Longfield Solar Farm

Chelmsford City Council

Unique reference: LOSF - 002

ExQ1 - Responses to Written Questions

**KEY**

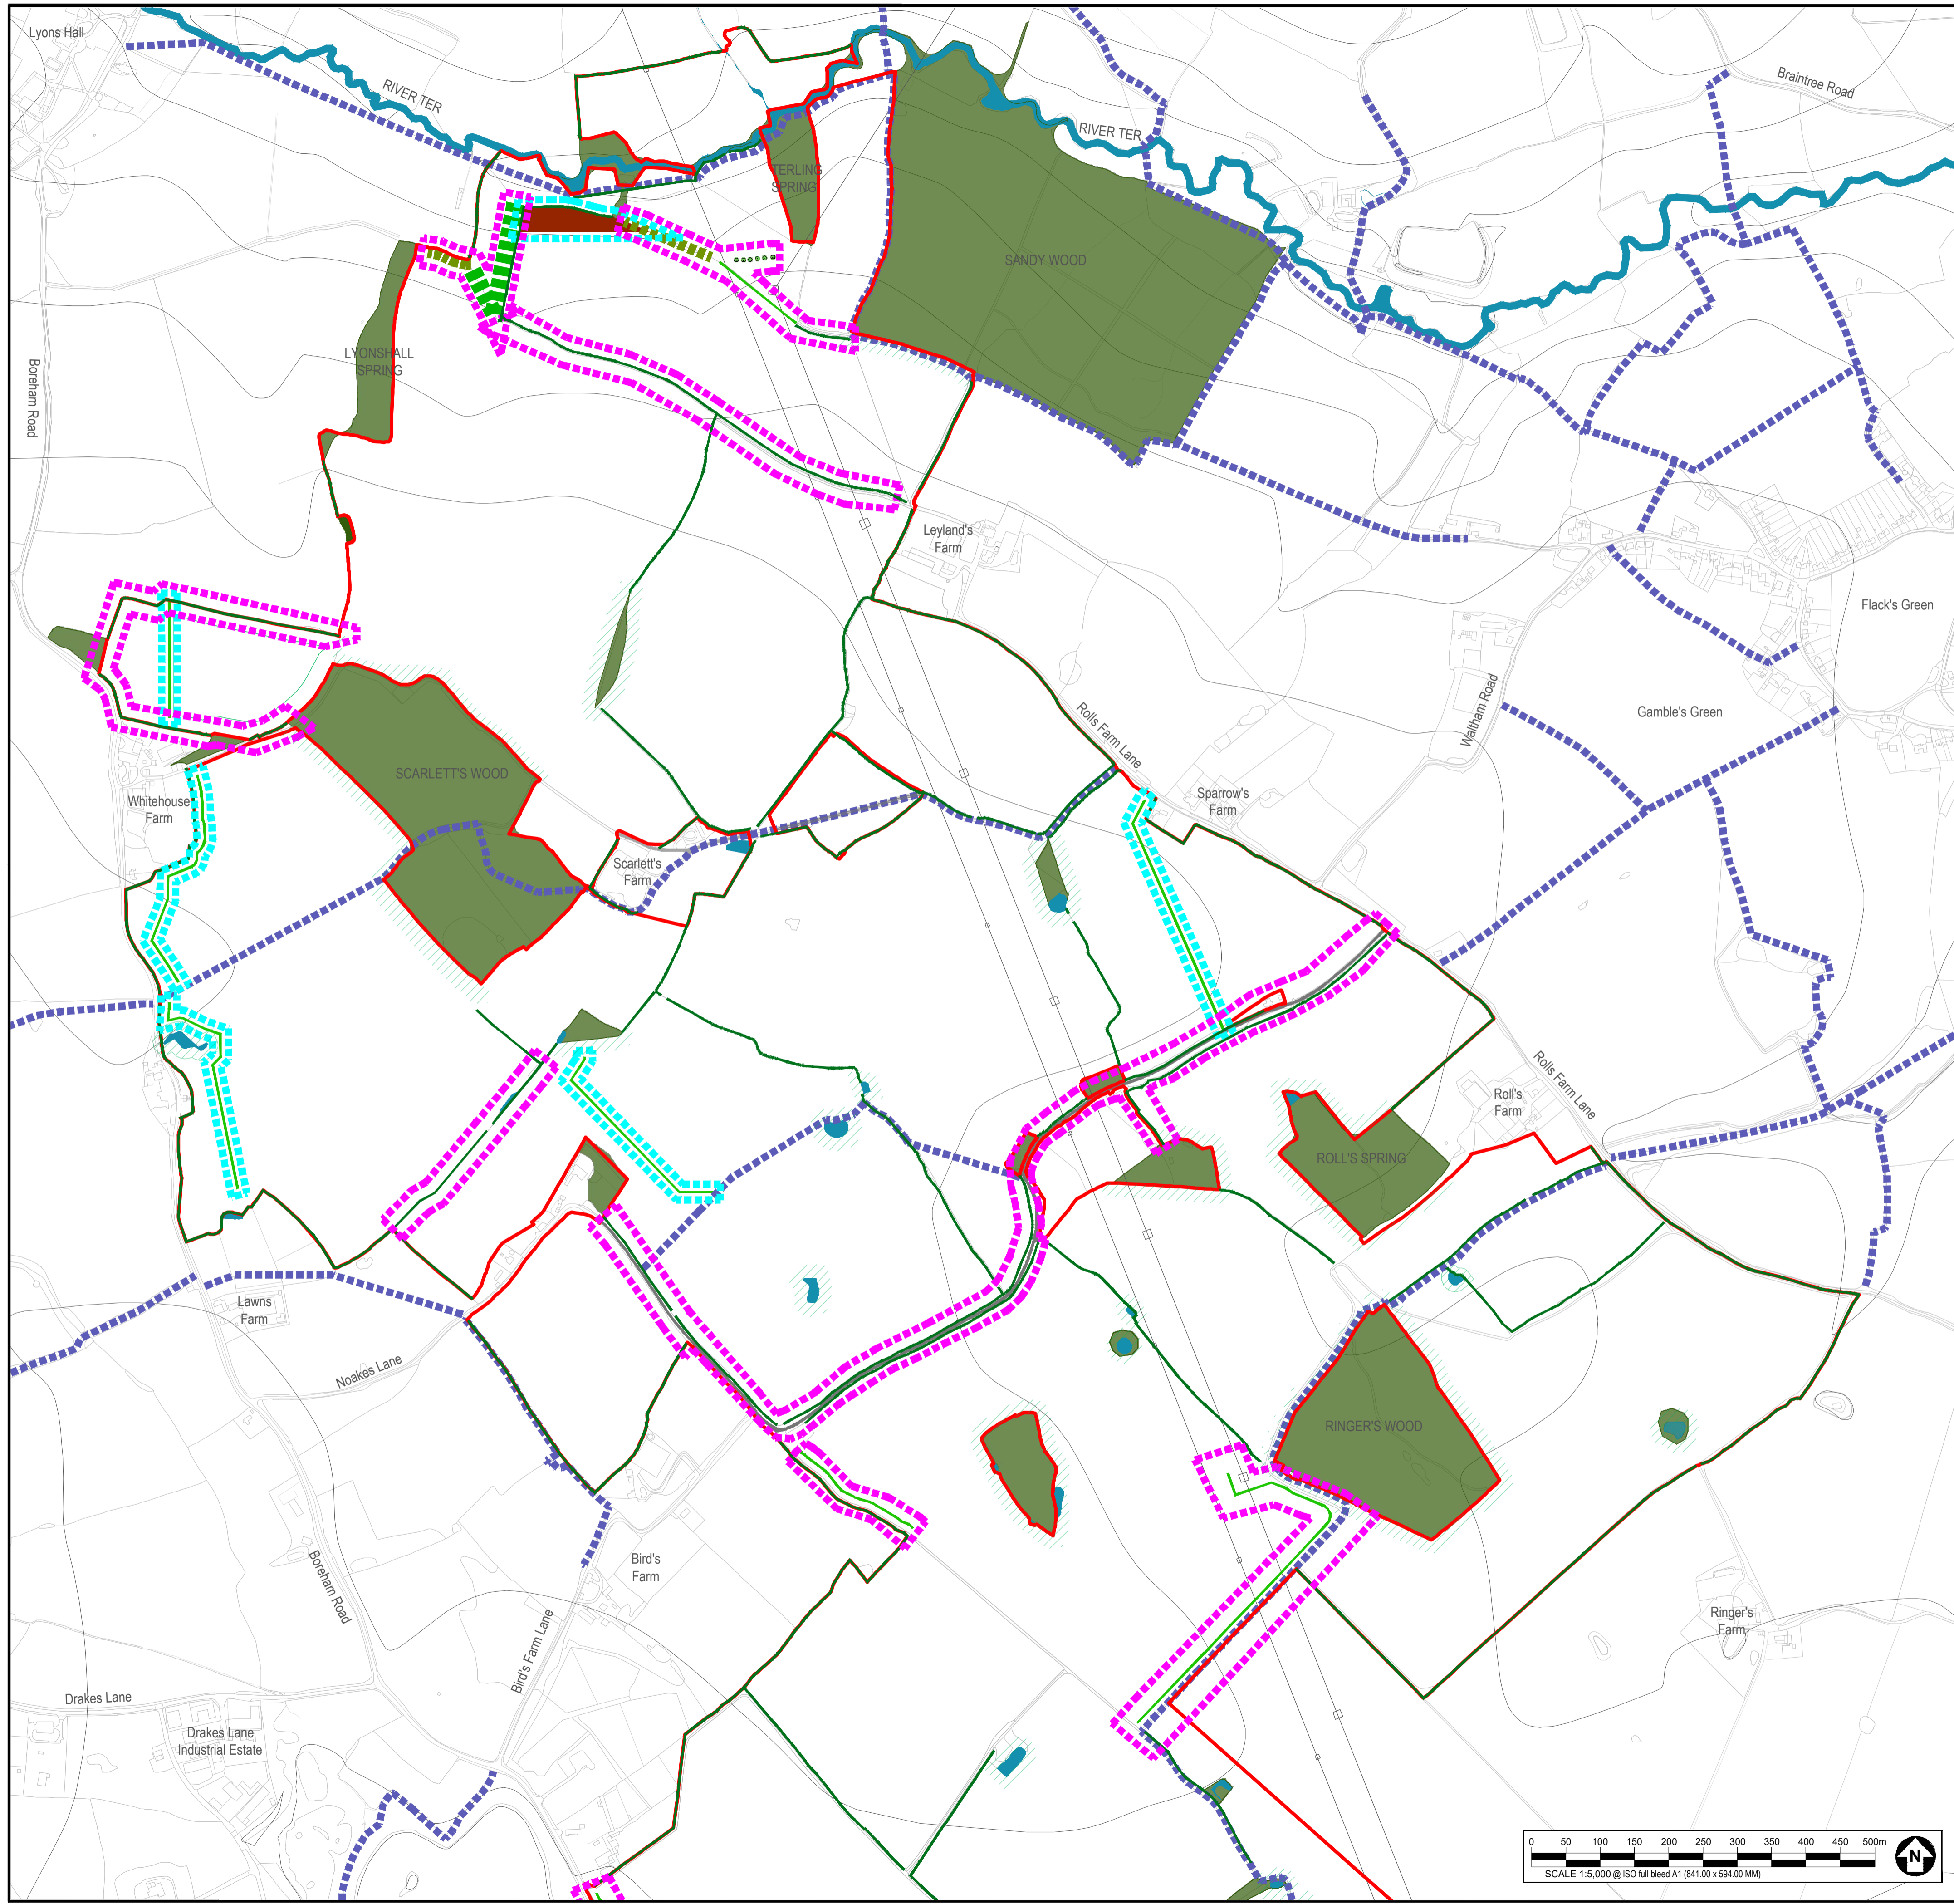
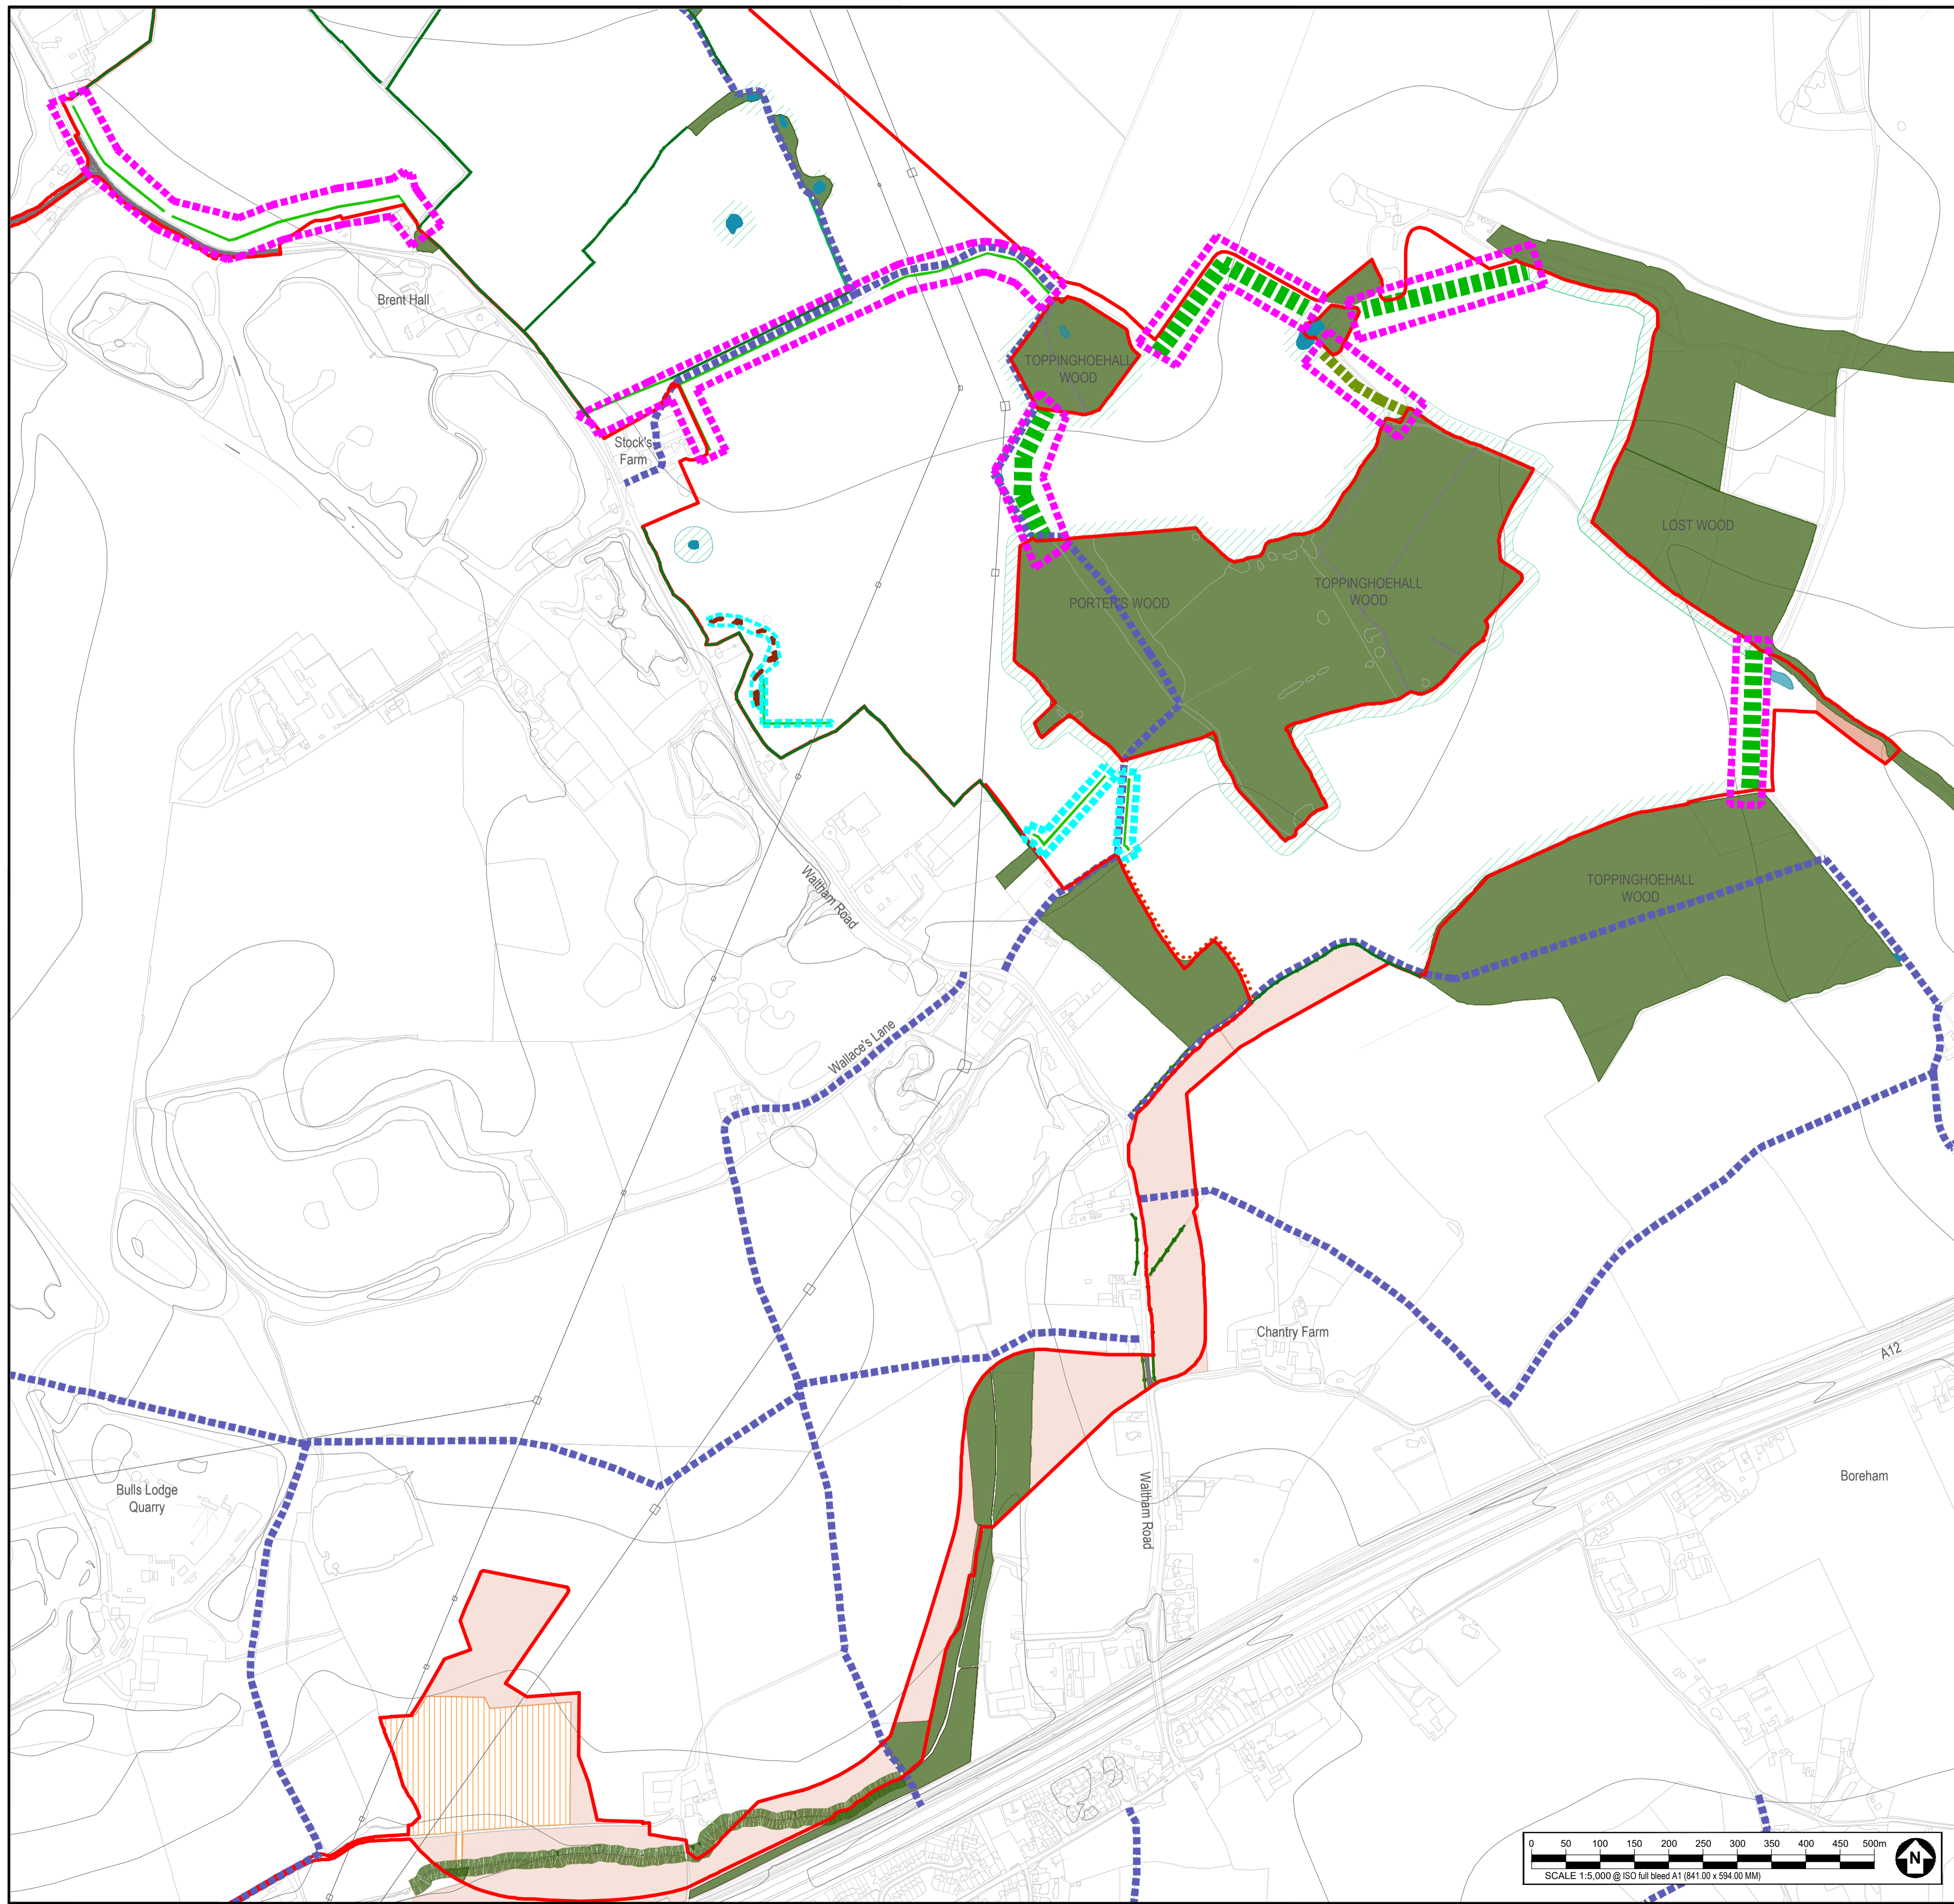
1.8.3	Host Authorities	Could the relevant Host Authorities confirm whether they are in agreement with the proposed landscaping mitigation measures and (as relevant) monitoring proposals, as set out in the Outline Landscape Masterplan [APP-179], the oCEMP [APP-214], oOEMP [APP-215] and the oLEMP[APP-217]?	<p>CCC confirm it is content in principle subject further to further discussion on the following three items:</p> <ol style="list-style-type: none"> 1. Approach to vegetation removal / management on Noakes Farm Lane (protected lane) 2. Screening of view from Viewpoint 45 (Essex Way north of River Ter) 3. Advance planting of PDA 1 scrub area
